CITY OF ALBUQUERQUE

Re: NMAC Building
1330 Cuesta Abajo
Traffic Circulation Layout
Engineer's/Architect's Stamp dated 1-20-16 (D16-D02F)

Based upon the information provided in your submittal received 2-5-16, the above referenced plan cannot be approved for Building Permit until the following comments are addressed:

SITE PLAN

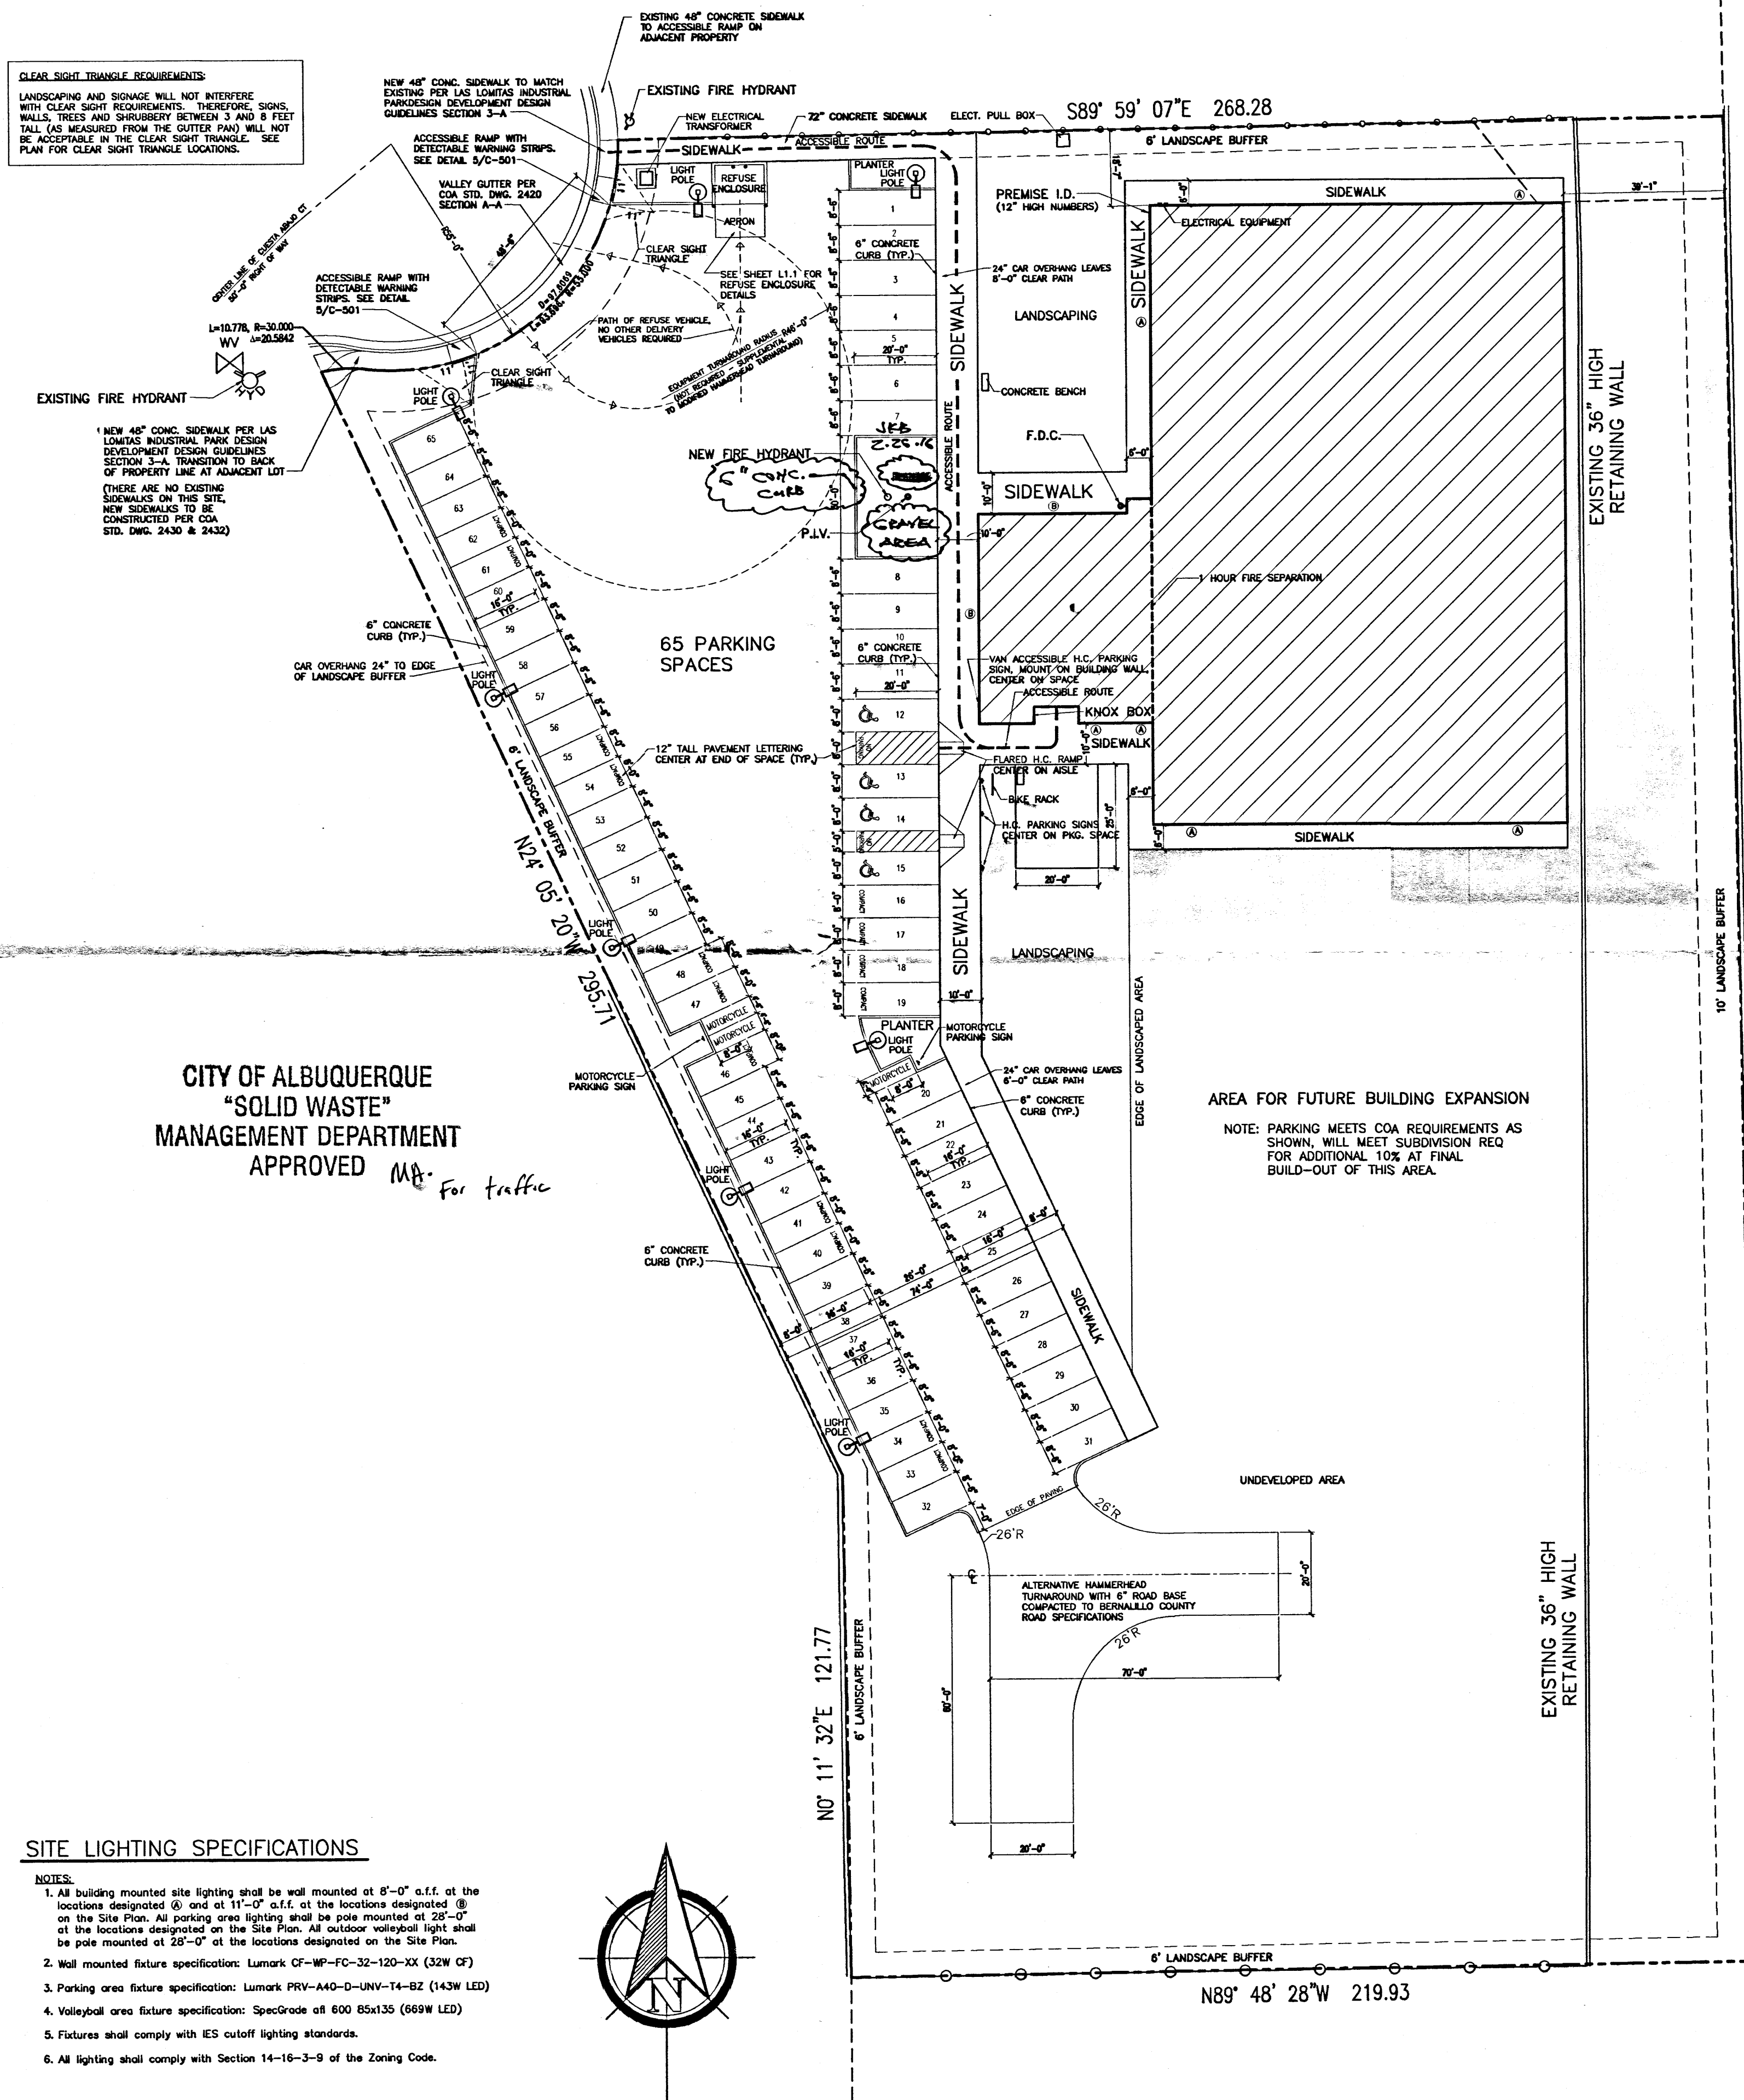
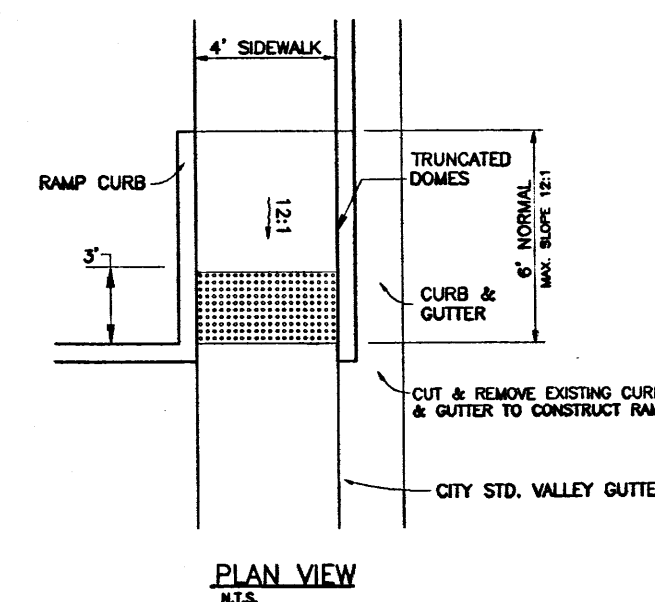
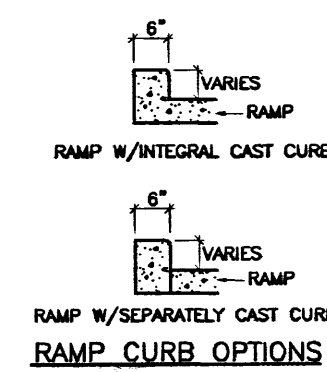
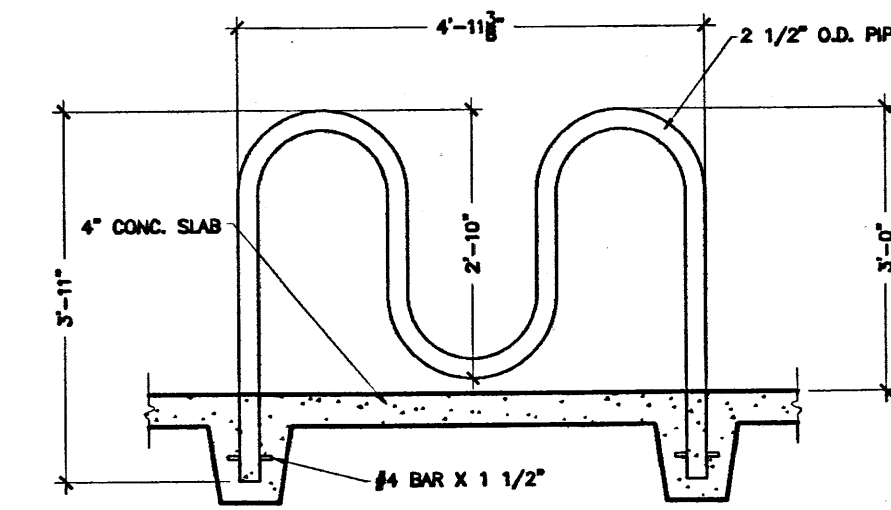
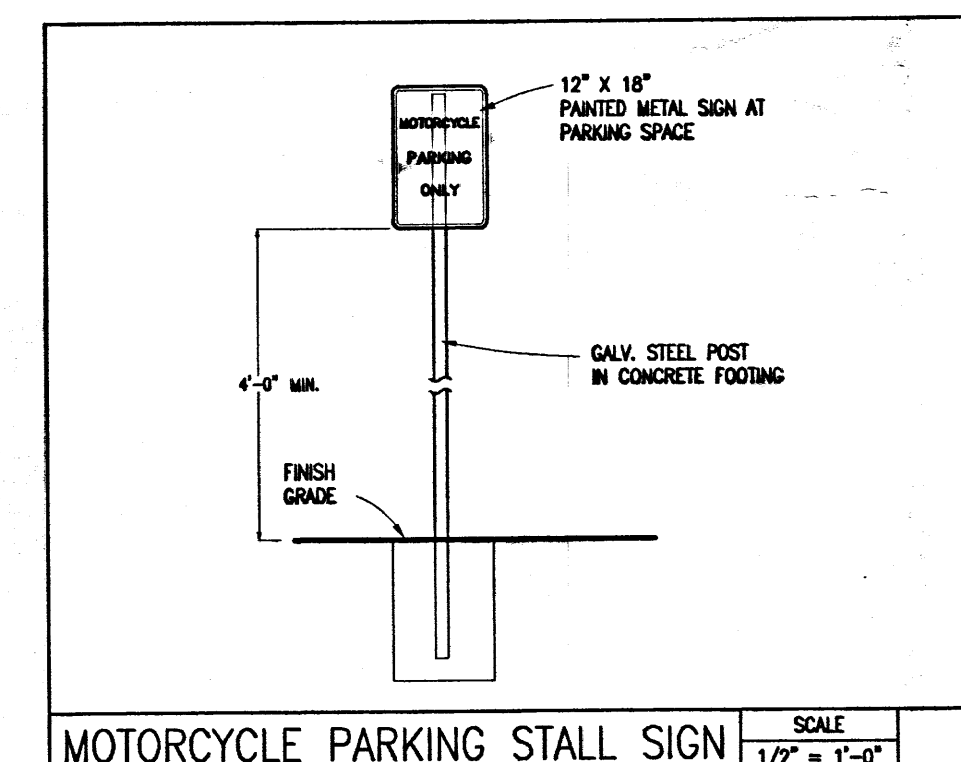
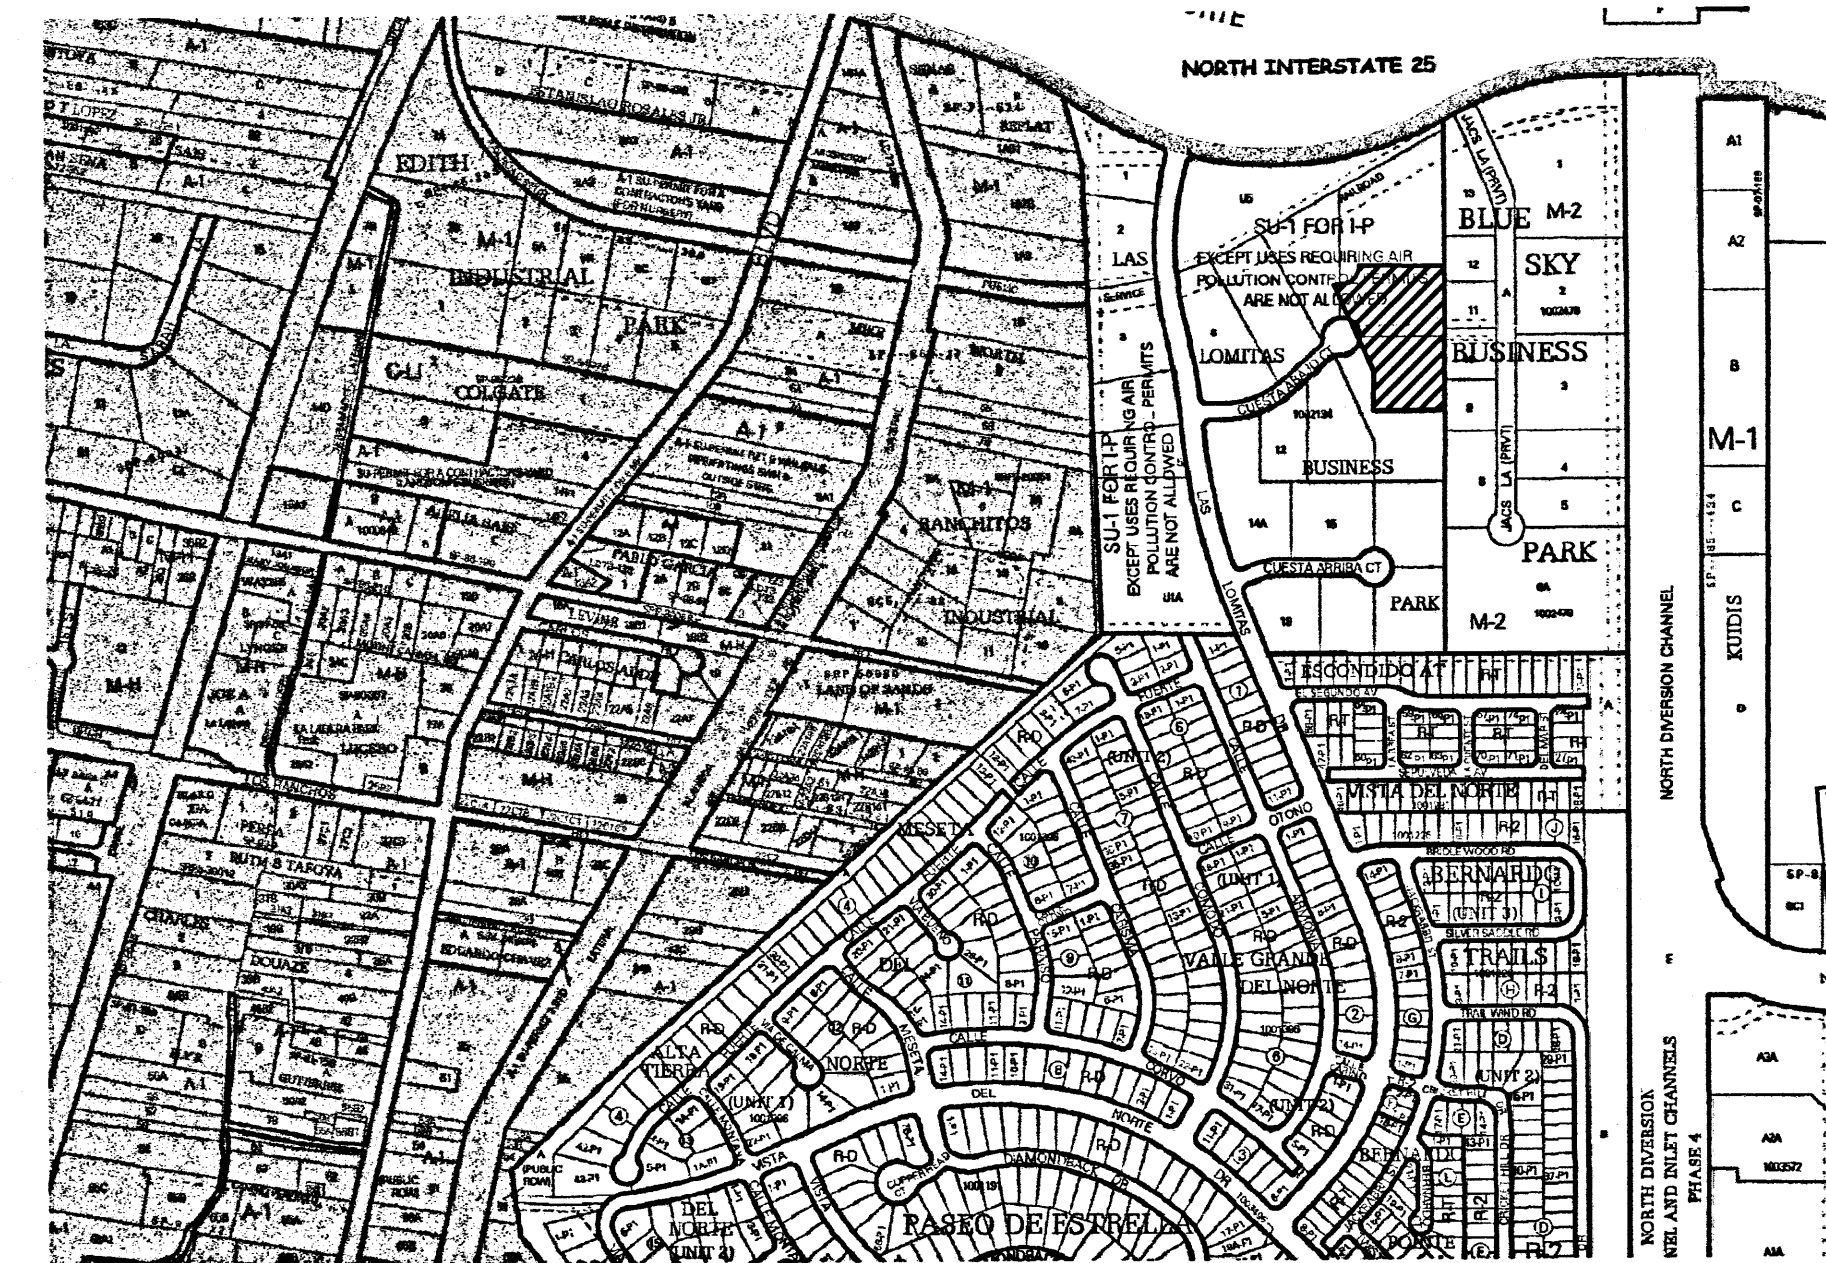
6. Per the DPM, a 6 ft. wide ADA accessible pedestrian pathway is required from the public sidewalk to the building entrances. Please clearly show this pathway and provide details of ADA approved ramps from Cuesta Abajo Ct.
